Online Comment

Application H16-0790-21
Location 32-33 Hall Place Spalding PE11 1SG
Proposal Proposed Signage

Name Spalding & District Civic Society
Address Mr Robert West 94 Spalding Common Spalding PE11 3AU

DESCRIPTION
EXISTING & PROPOSED SHOPFRONT
ELEVATION

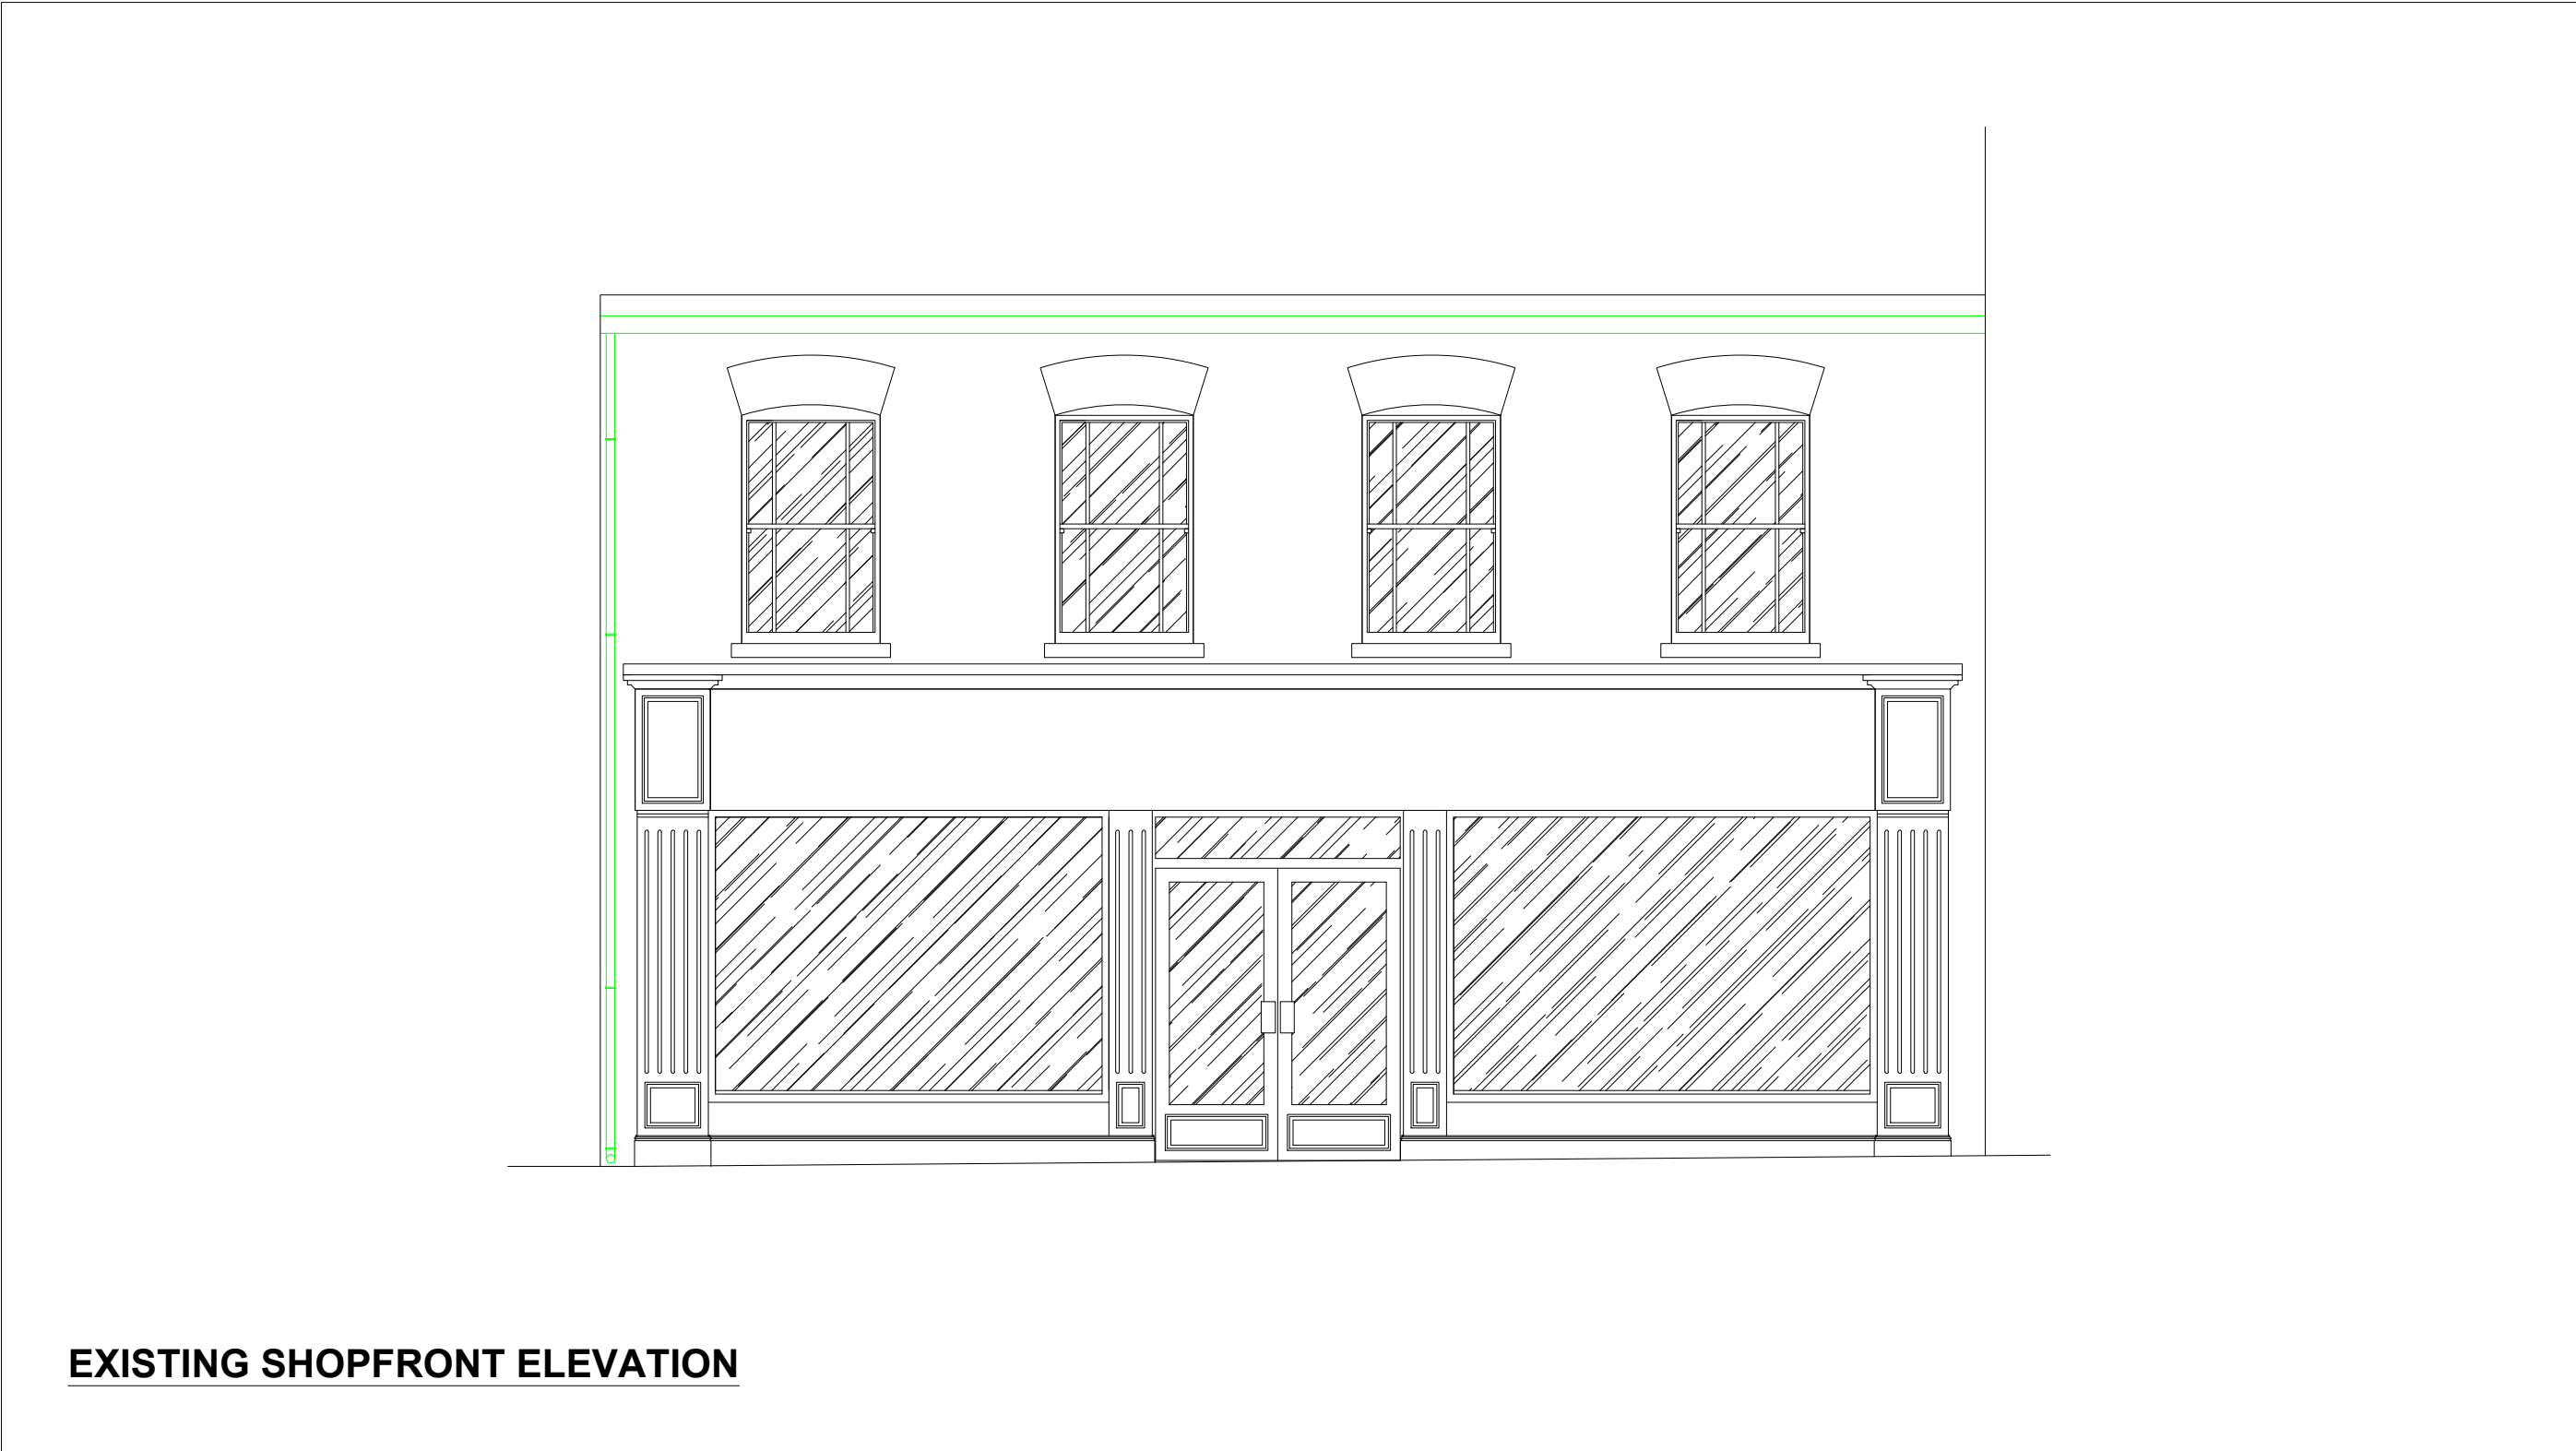
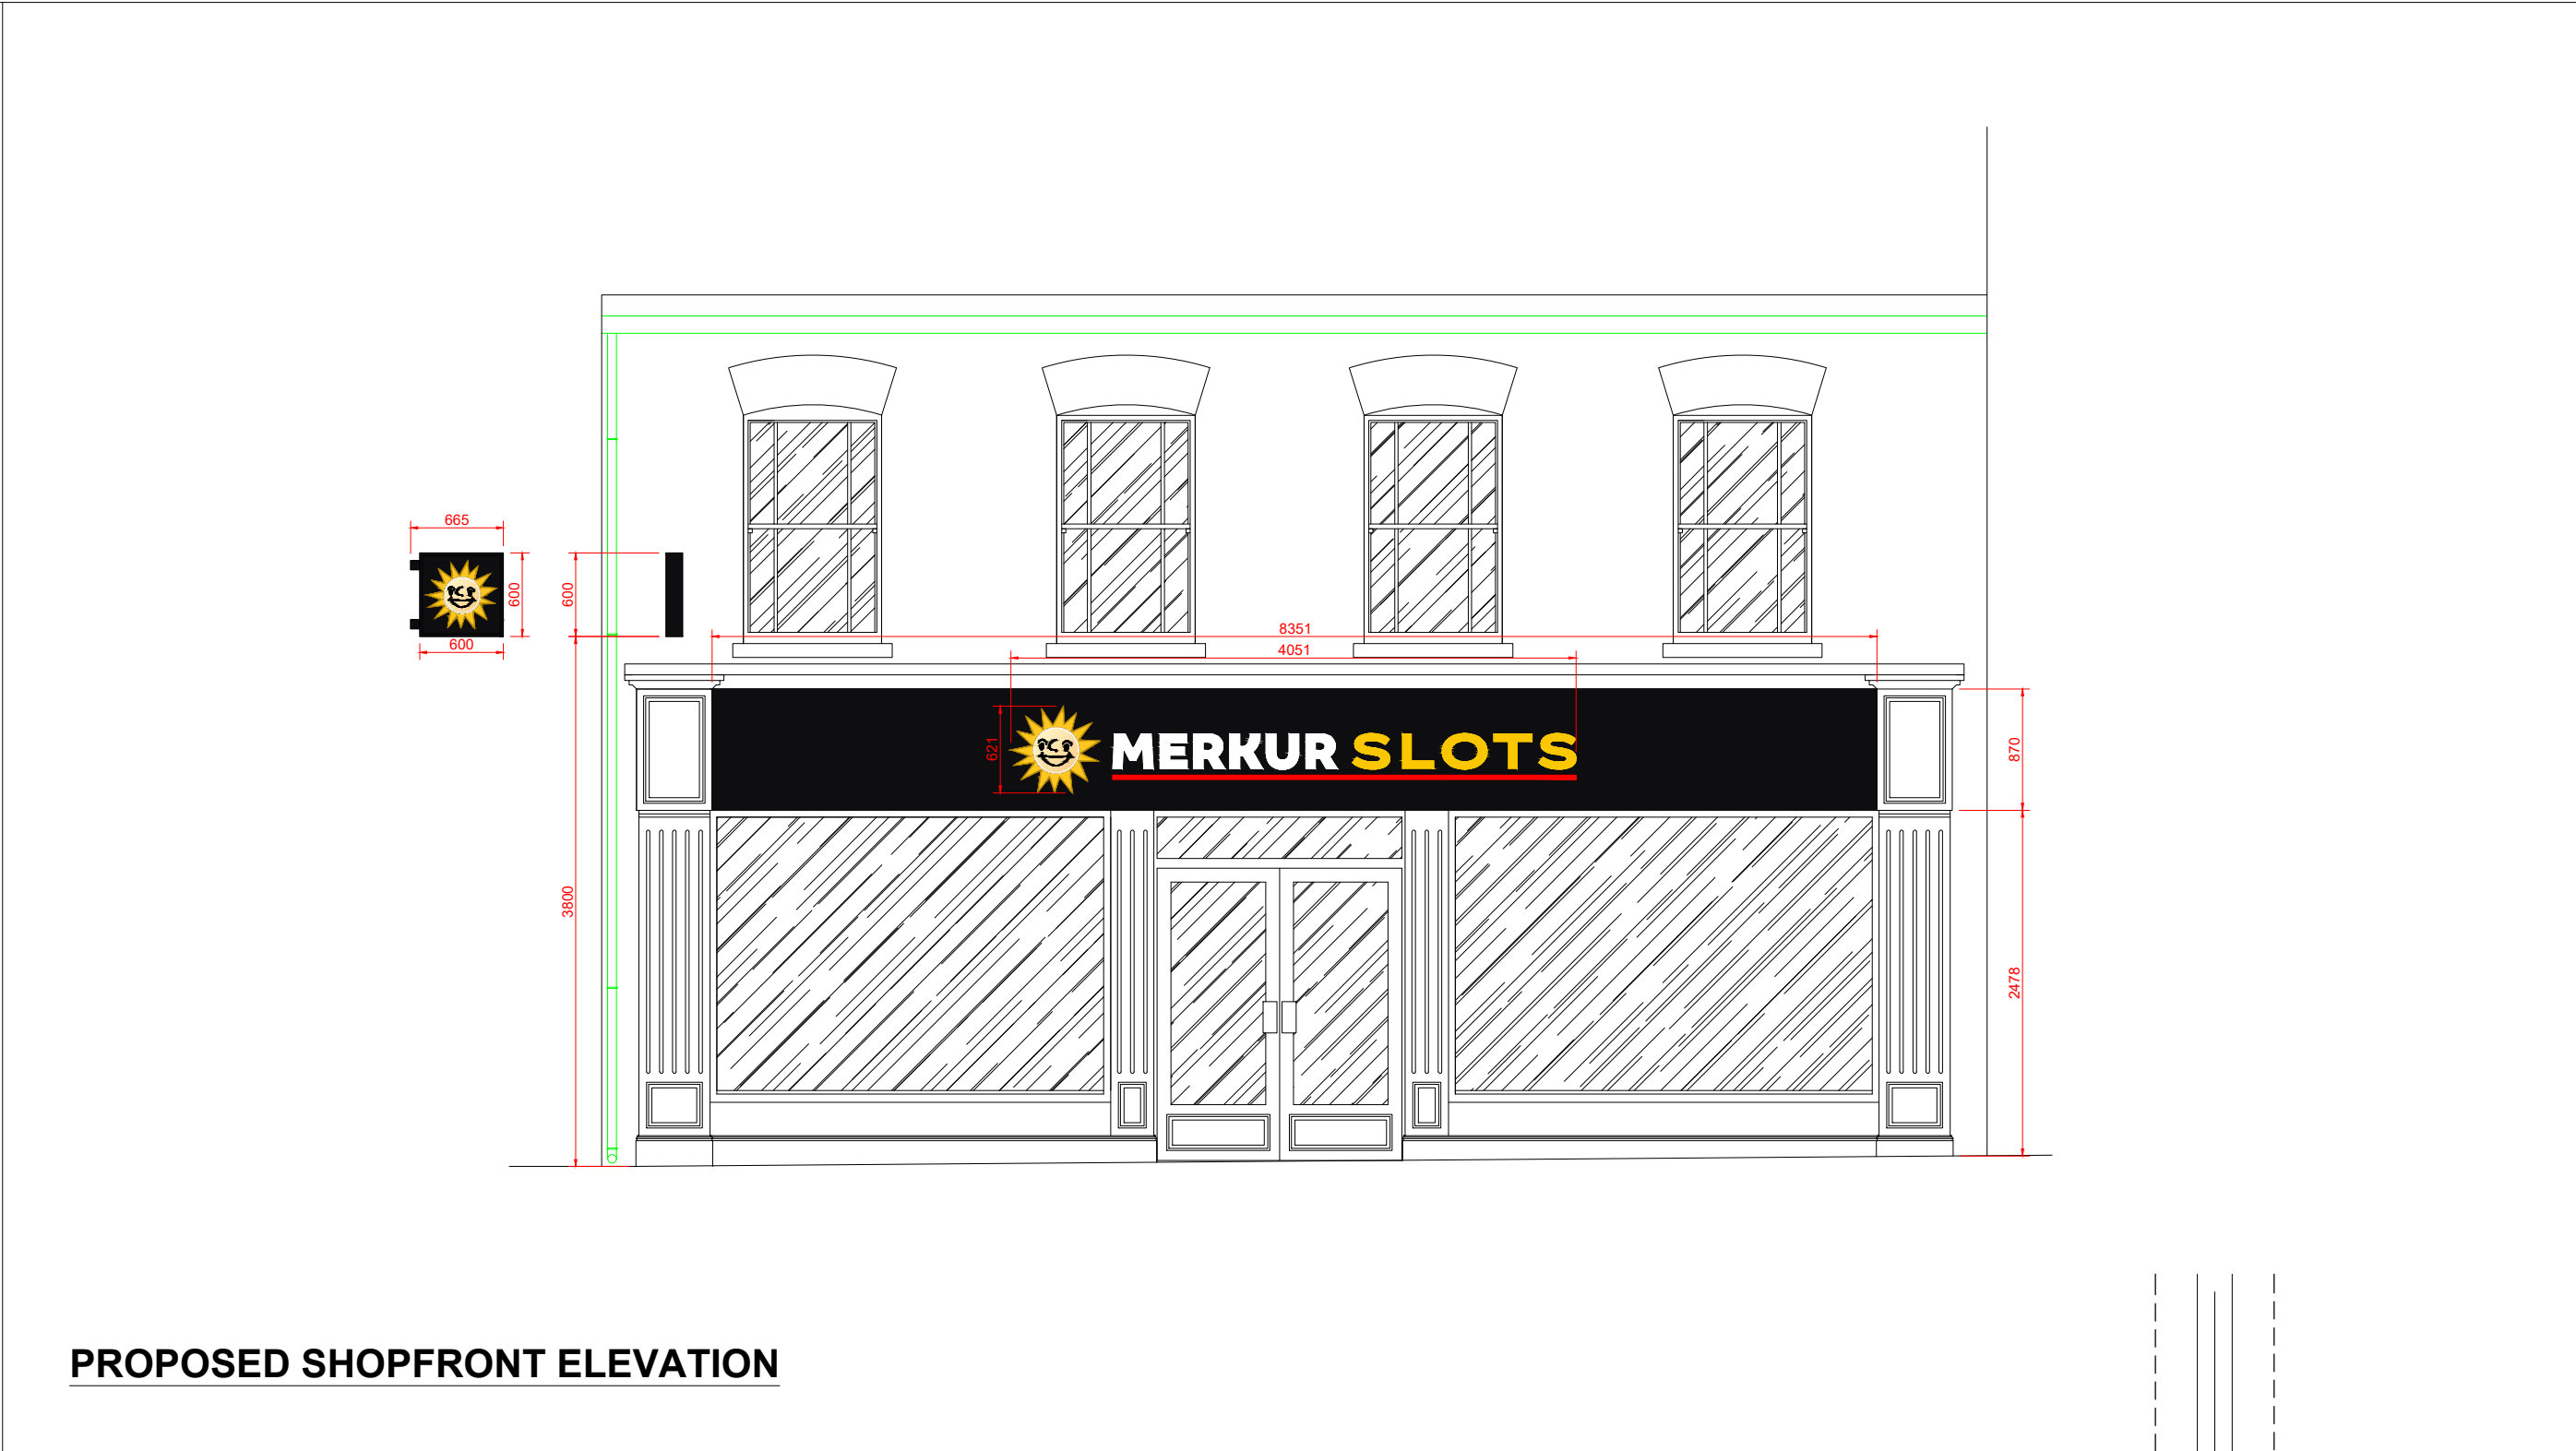
As the site is in the primary shopping area and the conservation area and is designated as a primary shopping front by policy 26 of the South East Lincolnshire Local Plan, we would like more detail as to how the applicant intends to make use of the shop display windows as the application is silent on this. The justification for policy 26 highlights the risks of clustering of non A1 frontages can create dead frontages thereby having an effect on footfall. This particular part of Hall Place already has a number of non A1 frontages in the form of a bank, an employment agency and is also opposite a building society and another bank.

We also refer to policy 29. This requires proposals to assess and mitigate against, any negative impact the proposal might have on the townscape. The applicant has not made that assessment and we therefore would like to the applicant to make that assessment and clarify the proposals for the display windows.

In the absence of such assessment and statement of mitigation, we feel that a condition should be considered to ensure that the windows are not blanked out by any form of vinyl advertising which would be detrimental to this prime area of the town and to the conservation area as a whole.
